Town & Country Planning Act 1990 (as amended) s211 Notice

Prior Notification of Work to Tree(s) in a Conservation Area

Development: 1no. Leyland Cypress tree (T1) to be felled.
1no. Group of mixed species (TG1) is to be cut back to the boundary line from base to upper extent where necessary.
1no. Group of mixed species (TG2) is to be cut back to the boundary line from base to upper extent where necessary.
Trees are within Angmering conservation area.

Location: Church Farm House Rectory Lane Angmering BN16 4JU

Tree Location plan

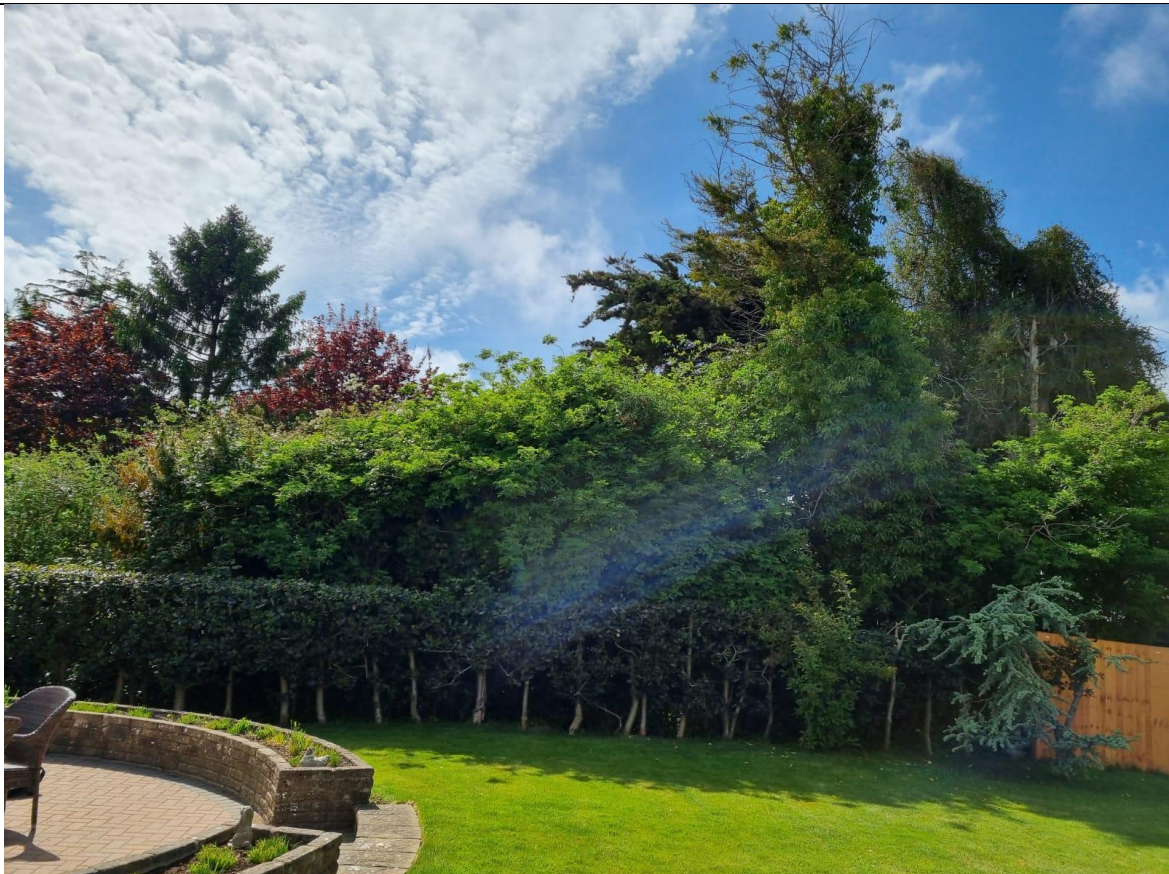
TG1 - please specify the number and species of the trees within the group. Please also specify the proposed works for each tree i.e. if a crown reduction you are required to provide the proposed height and spread measurements for each tree

For clarity please submit one sketch plan clearly showing the location of each tree. As the proposed works is for more than one tree, the trees should be clearly labelled and cross referenced to the application form.

TG2 - please specify the number and species of the trees within the group. Please also specify the proposed works for each tree i.e. if a crown reduction you are required to provide the proposed height and spread measurements for each tree.
